February 11, 2025

**SUBJECT: WDFW COMMENTS ON CU-25-00001 HAYFORD WELL COMMUNICATIONS TOWER**

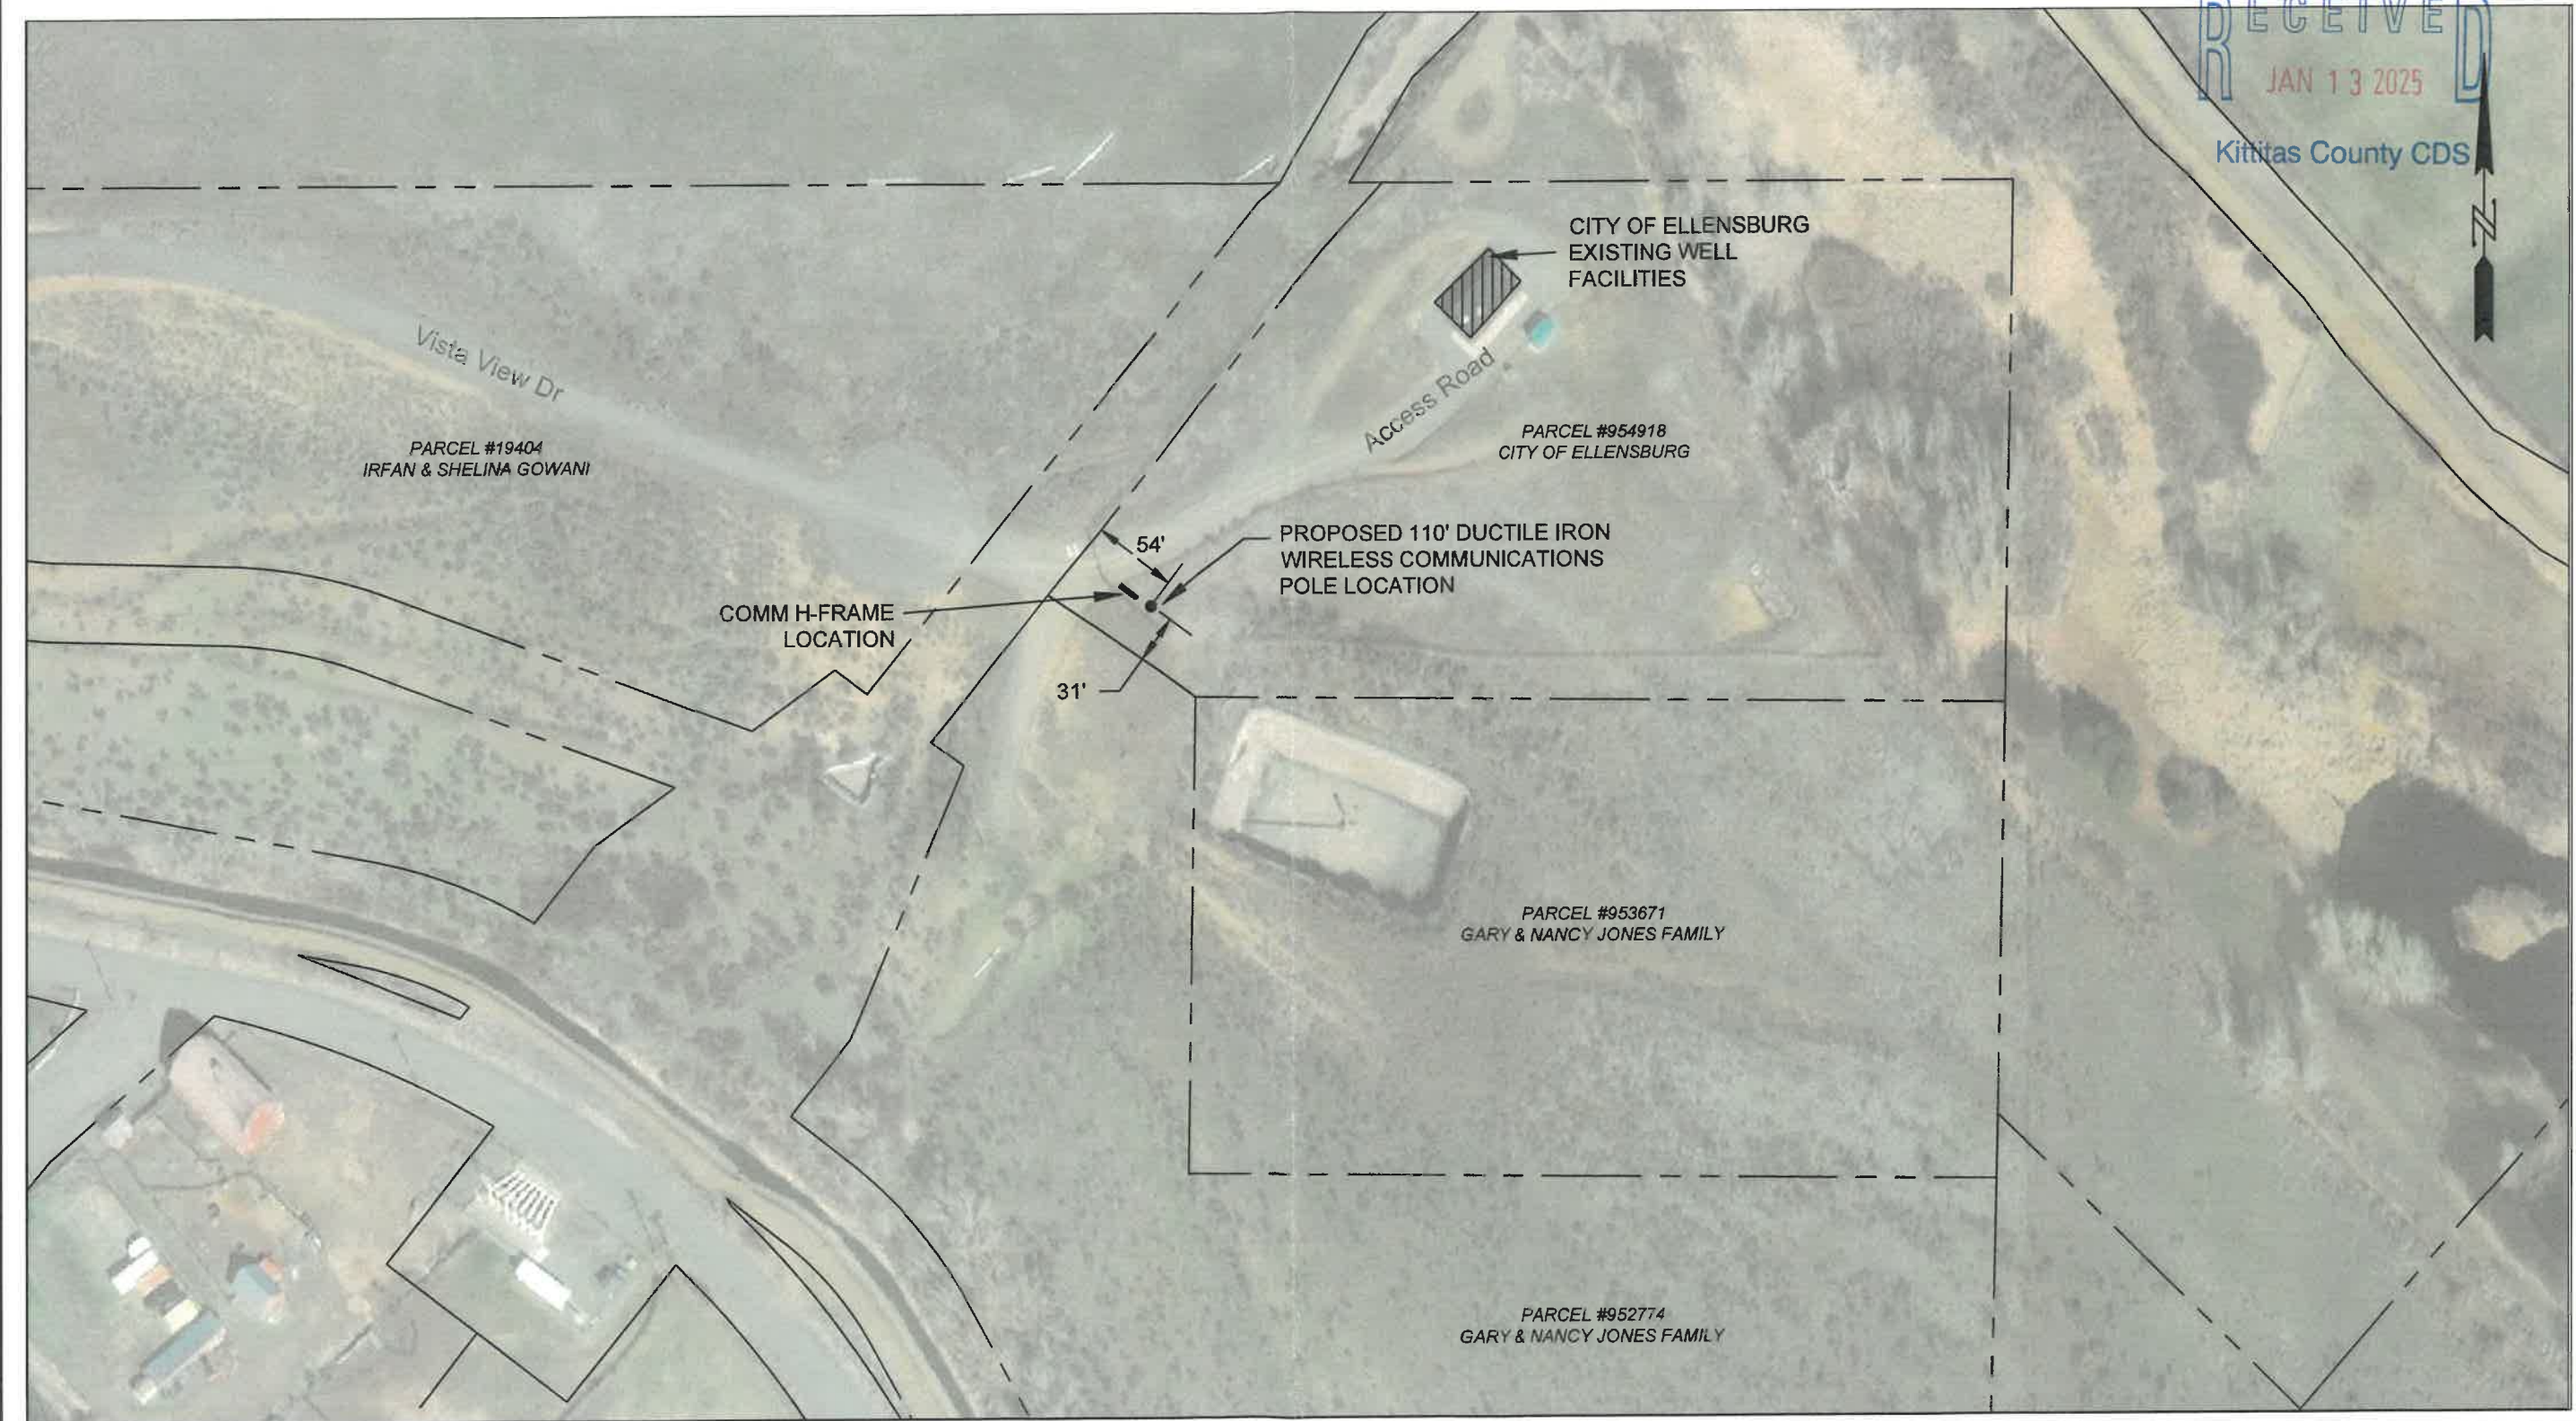
The application materials available for review do not discuss the overall area of disturbance for this project and do not address the potential impacts to shrubsteppe habitat with construction of this project. **We request that a complete site plan be provided that includes all temporary and permanent disturbance so all potential impacts to shrubsteppe habitat can be reviewed and properly mitigated for, consistent with the County's critical areas ordinance.**
